**City of Portland, Maine - Building or Use Permit**

Permit No: 04-0515	Date Applied For: 04/29/2004	CBL: 138 C008001
-----------------------	---------------------------------	---------------------

Proposed Use: 3 unit w/replaced front porch	Proposed Project Description: Replace existing front porch
--	---

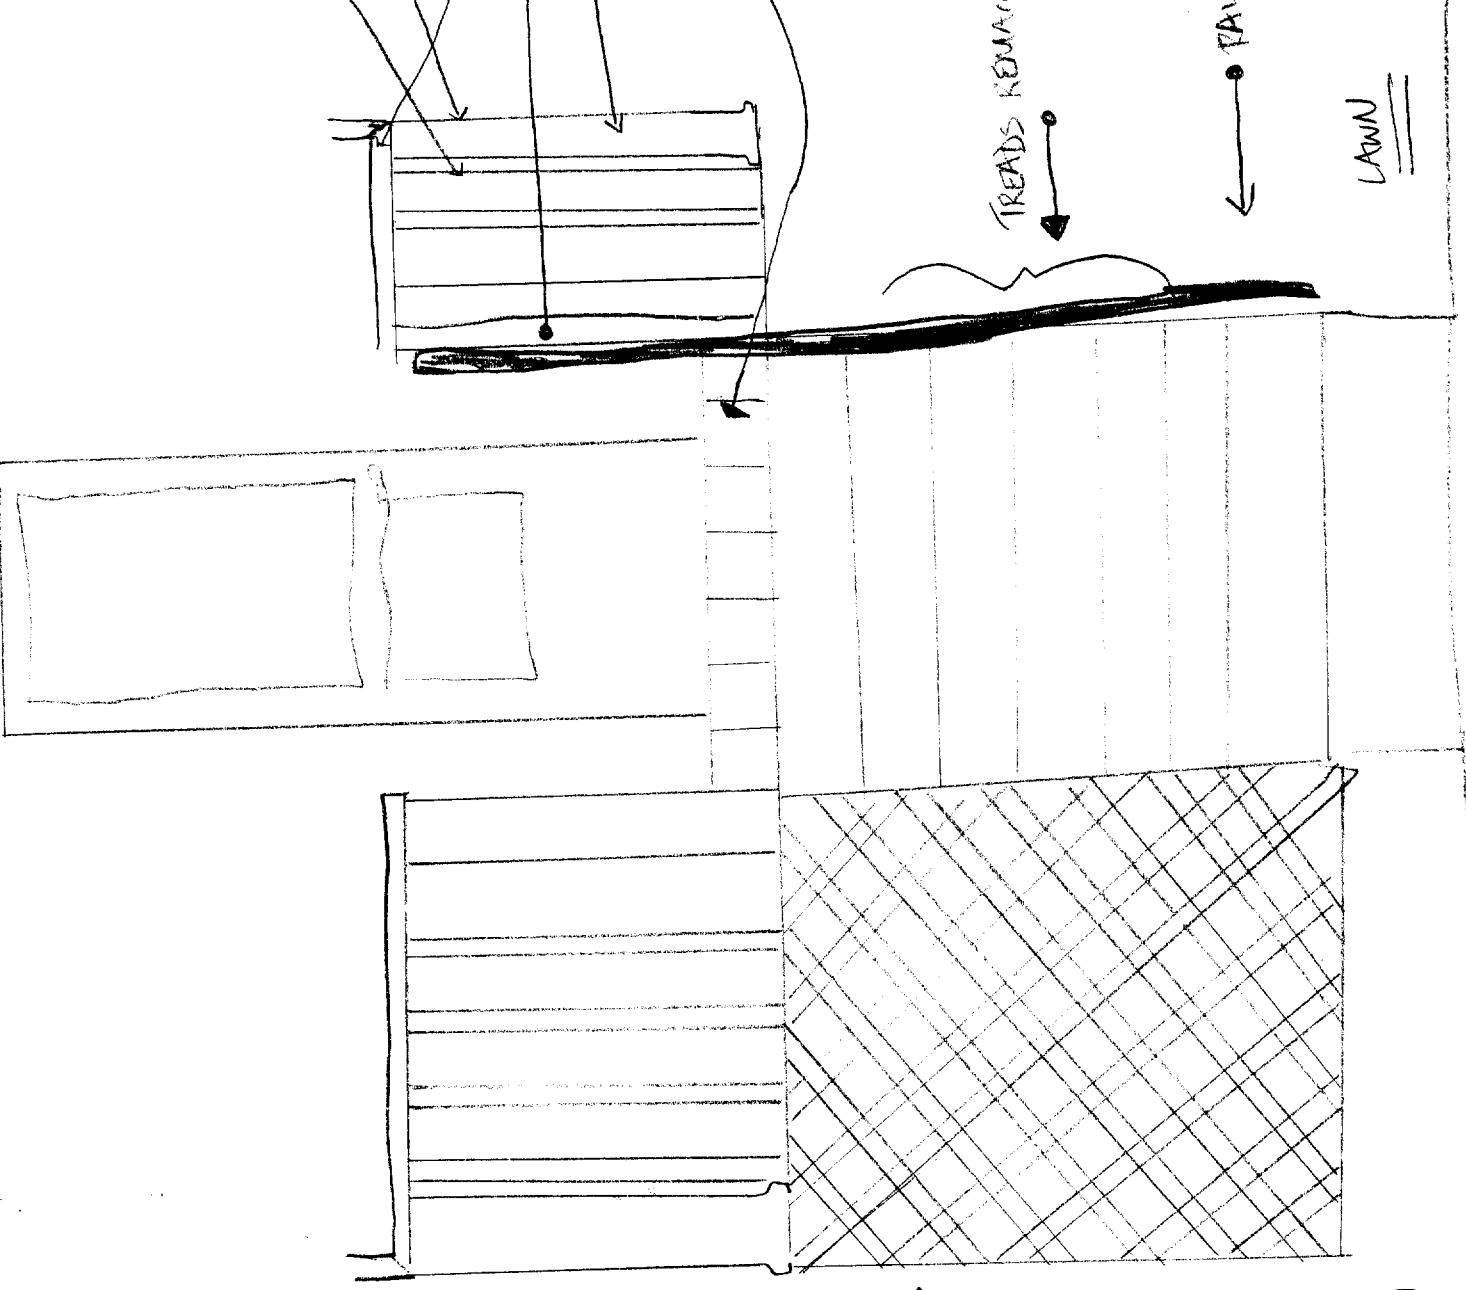
Dept: Building      Status: Approved with Conditions      Reviewer: Mike Nugent      Approval Date: 05/10/2004  
 Note:      Ok to Issue:   
 1) Ballusters must have openings less than 4 " (not 4") Owner notified
